945 Bank Street (Lansdowne 2.0 – North Side Stands) | Formal Review | Site Plan Control Application | City of Ottawa, Ottawa Sports and Entertainment Group, Brisbin Brook Beynon Architects, Fotenn Planning + Design, CSW, ERA Architects

DWG. TITLE **LANDSCAPE PLAN
 GROUND FLOOR**

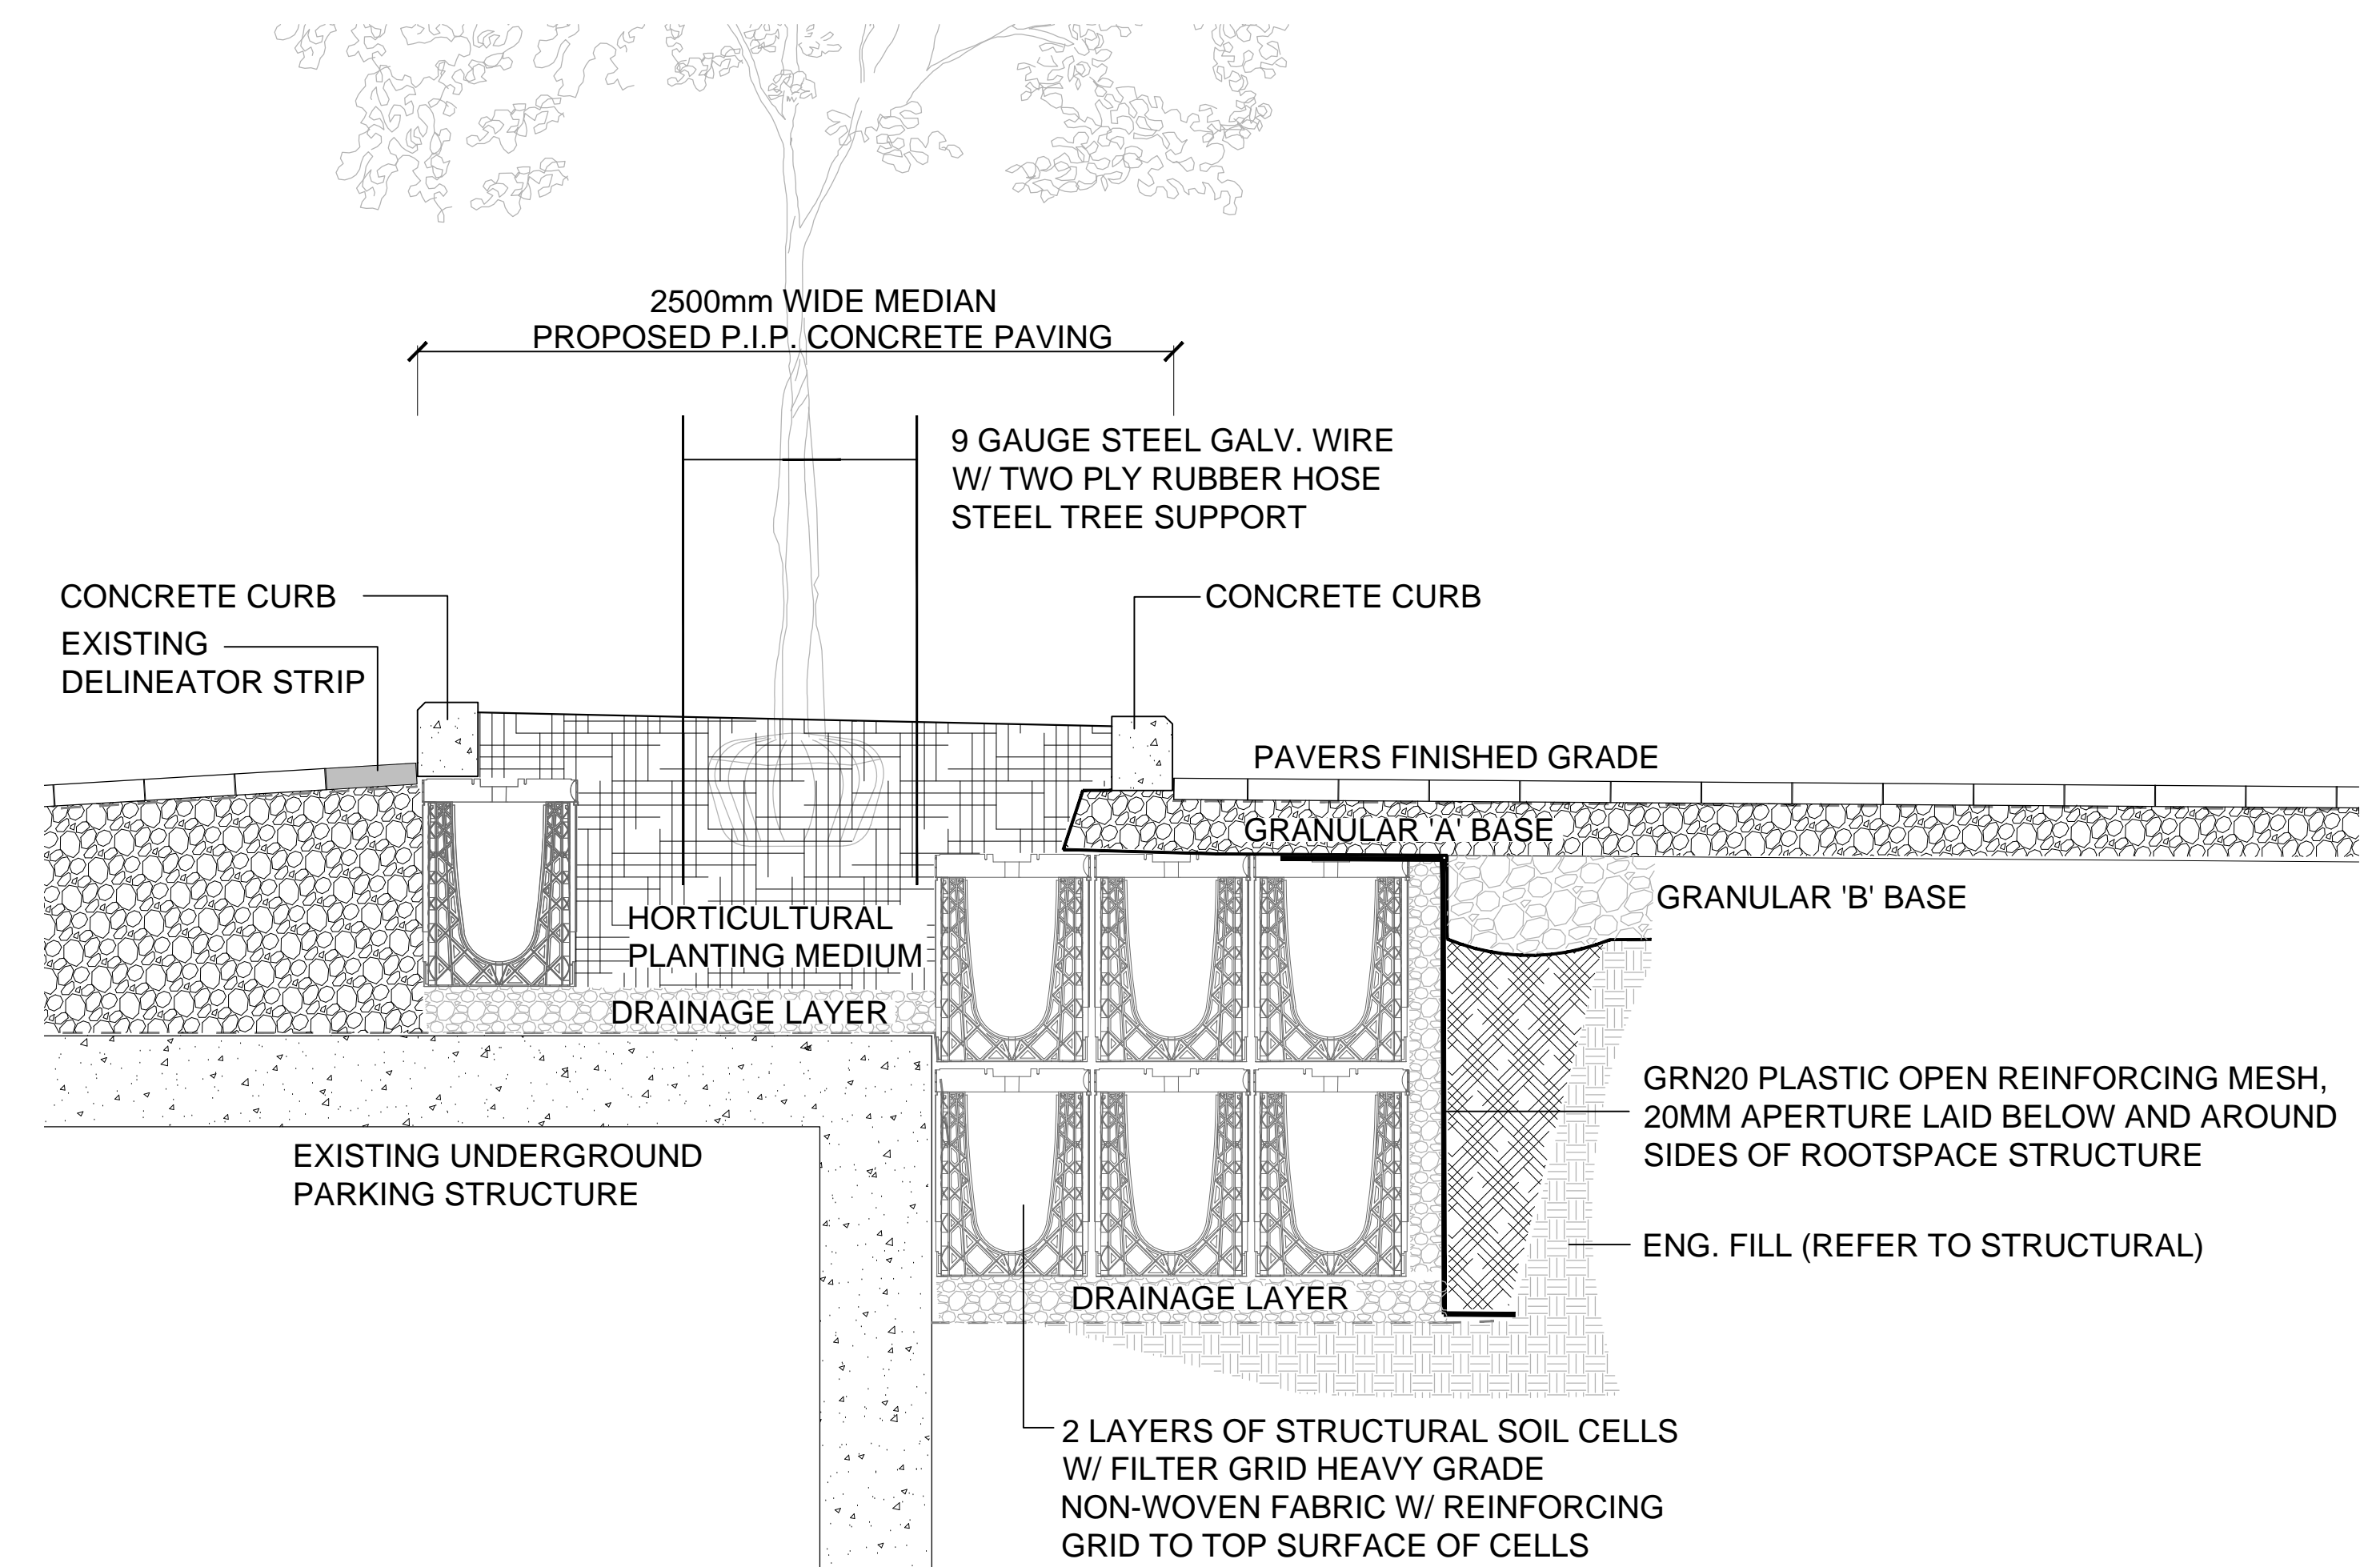
- The Panel recommends that the fan zone and parking lane should prioritize the pedestrian experience, ensuring that even when vehicles are present, the space is perceived as an extension of the public realm.

- The Panel suggests integrating warm tones and dynamic design elements into the landscape to counteract the currently neutral and gray surroundings.
- The Panel recommends that the interface between the stadium and surrounding spaces should be enhanced to encourage active public engagement, even outside event times.
 - Consider ways of enhancing the pedestrian experience to ensure that public spaces feel vibrant and welcoming. The potential use of thermoplastic patterning or other paving treatments would help animate expansive paved areas.
- The Panel encourages exploring more options for the transition of the laneway into a functional and flexible space. It should be more than just an asphalt surface, with opportunities for it to serve as a fan zone, gathering space, or other adaptable public use.

- The Panel encourages the use of sustainable materials and green infrastructure within the public realm, especially in the Lane, including permeable paving and increased vegetation.
- There is a suggestion to incorporate green elements such as climbing vines, shade structures, and integrated landscaping to soften the architectural massing and improve environmental performance.
- The Panel suggests that the planters should be enlarged where possible and be designed to incorporate green infrastructure solutions for stormwater management and ecological benefits.
- The Panel suggests exploring opportunities for dynamic and energy-efficient lighting to ensure safety while minimizing unnecessary light pollution.

SCALE	1 : 400	DWG. NO.	NS-A3-001"
PROJ. NO.	2008.3

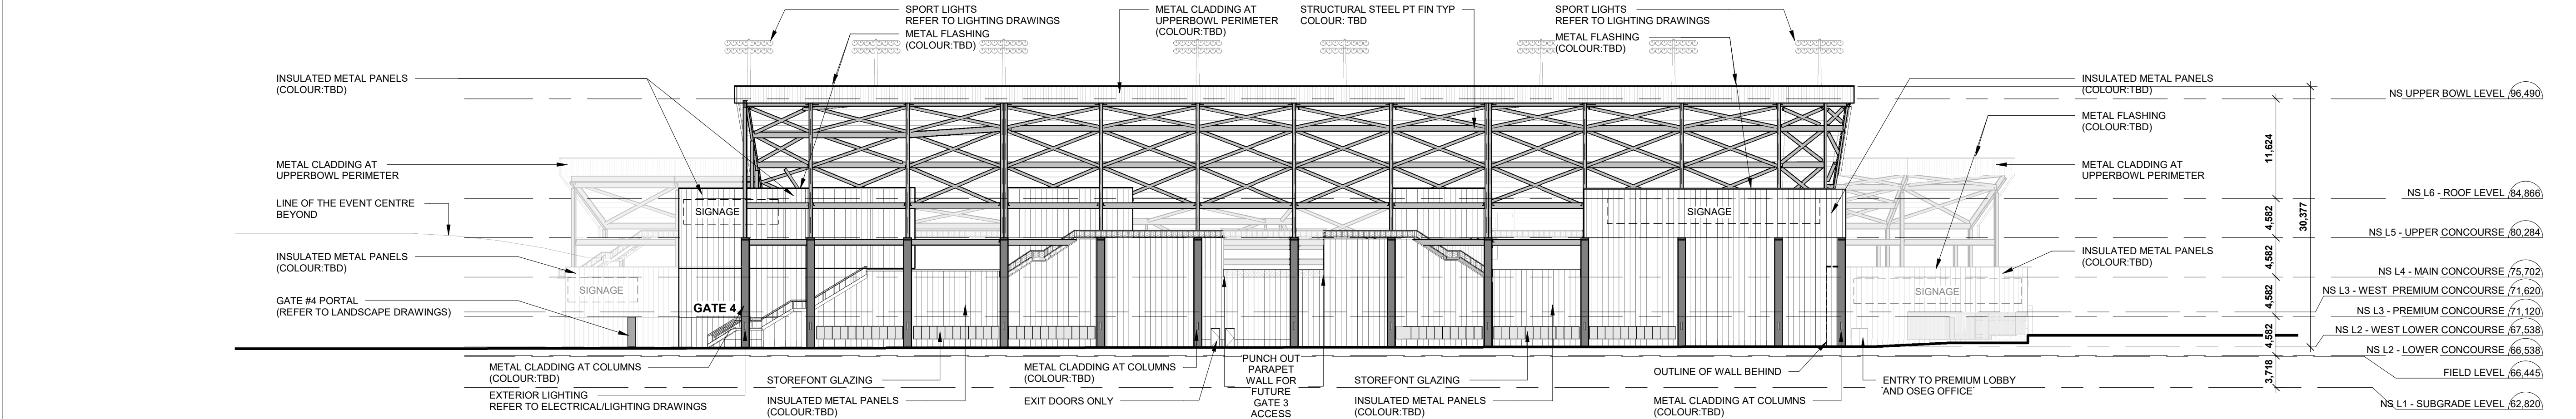
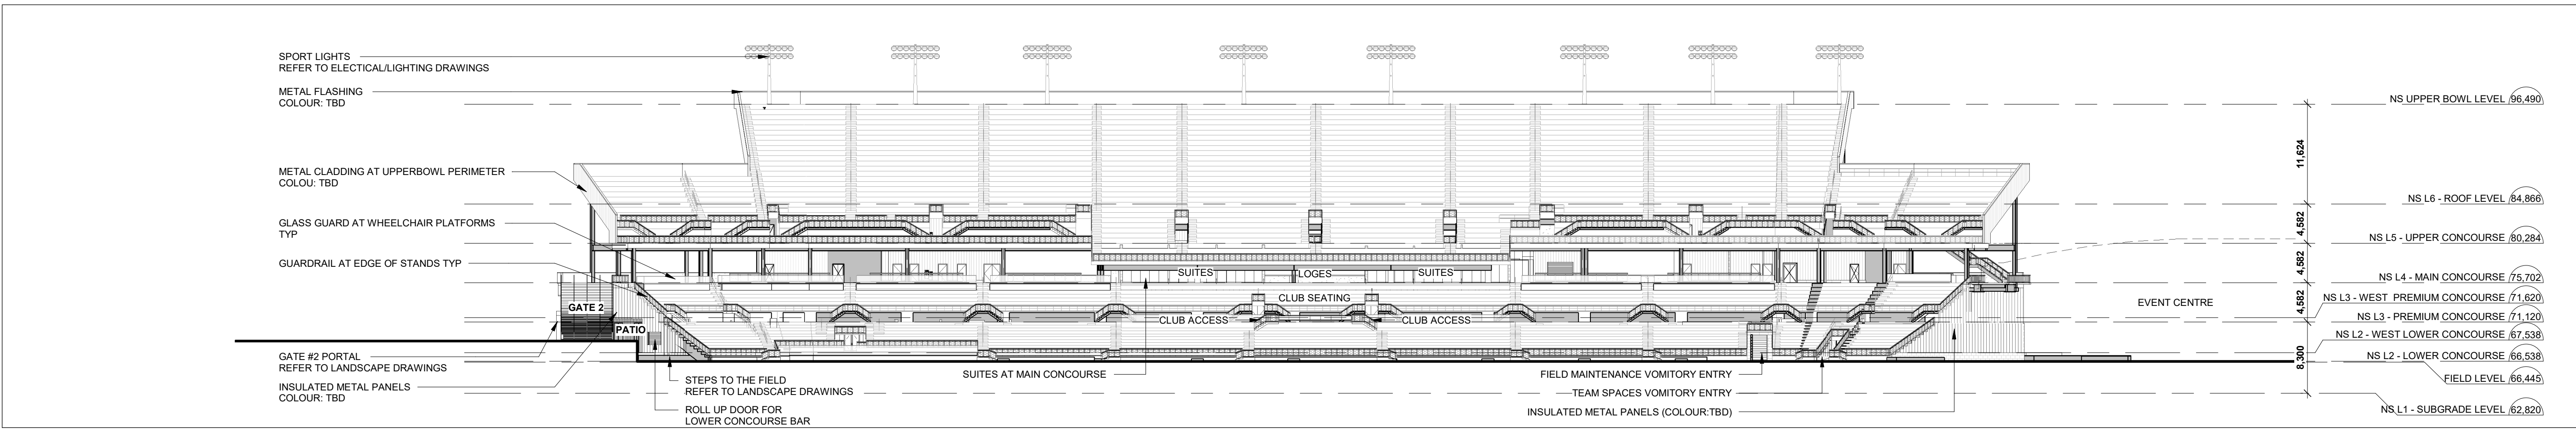
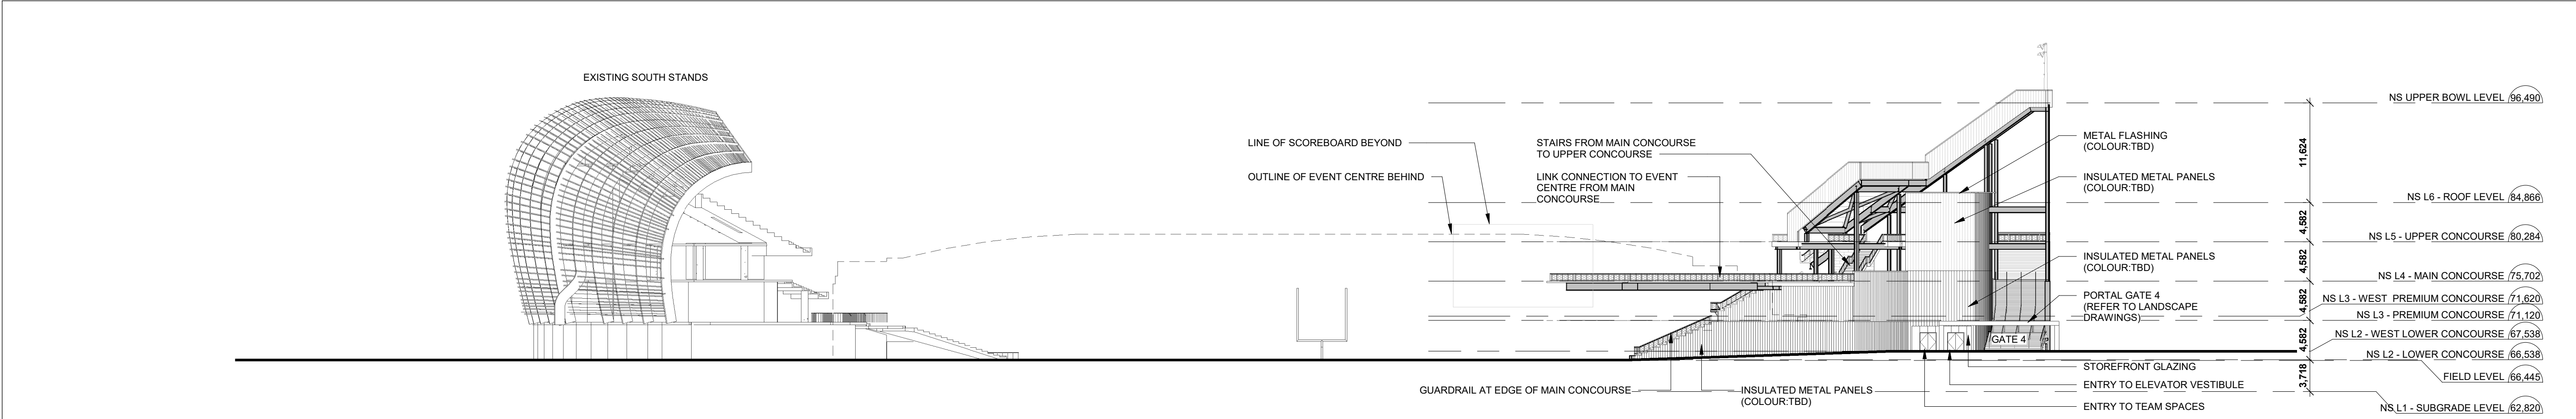
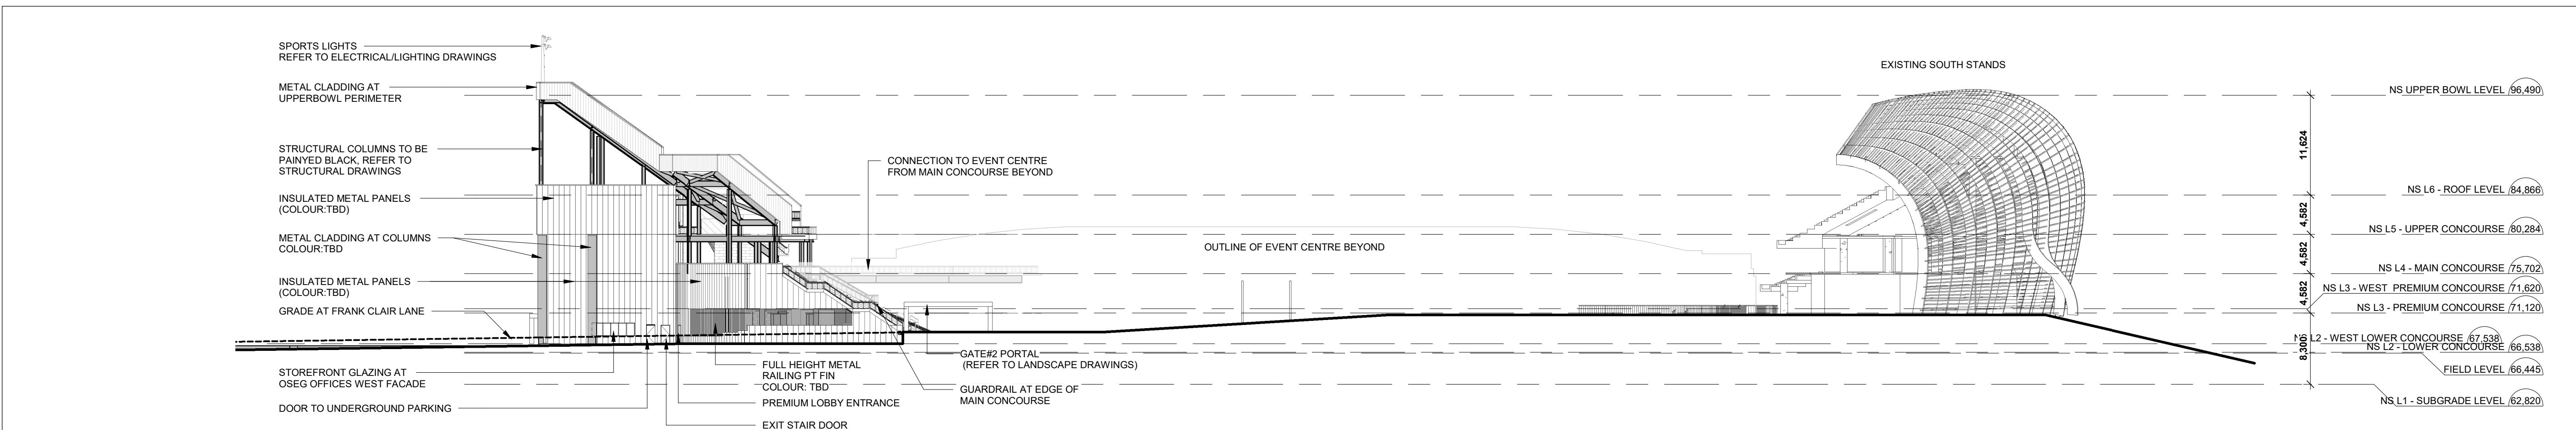
- The Panel supports the introduction of a warmer color palette and recommends extending this approach into the landscape design.
- The Panel suggests that the treatment of the upper levels of the stadium requires refinement, with a focus on embracing the steel structure and ensuring a cohesive and polished architectural expression.

- The Panel recommends that the architectural relationship between the arena and the adjacent building be further refined to establish a stronger dialogue through materiality, massing, and articulation.

- The Panel suggests that the use of metal panels and curved elements should be explored to create a more seamless and fluid architectural transition between building volumes.

- The Panel recommends further collaboration with the project structural engineers to enhance the detailing and articulation of steel members to elevate the overall design quality.

- The Panel recommends exploring a stronger upper and lower volume expression to reduce the perceived scale of the stadium stands.
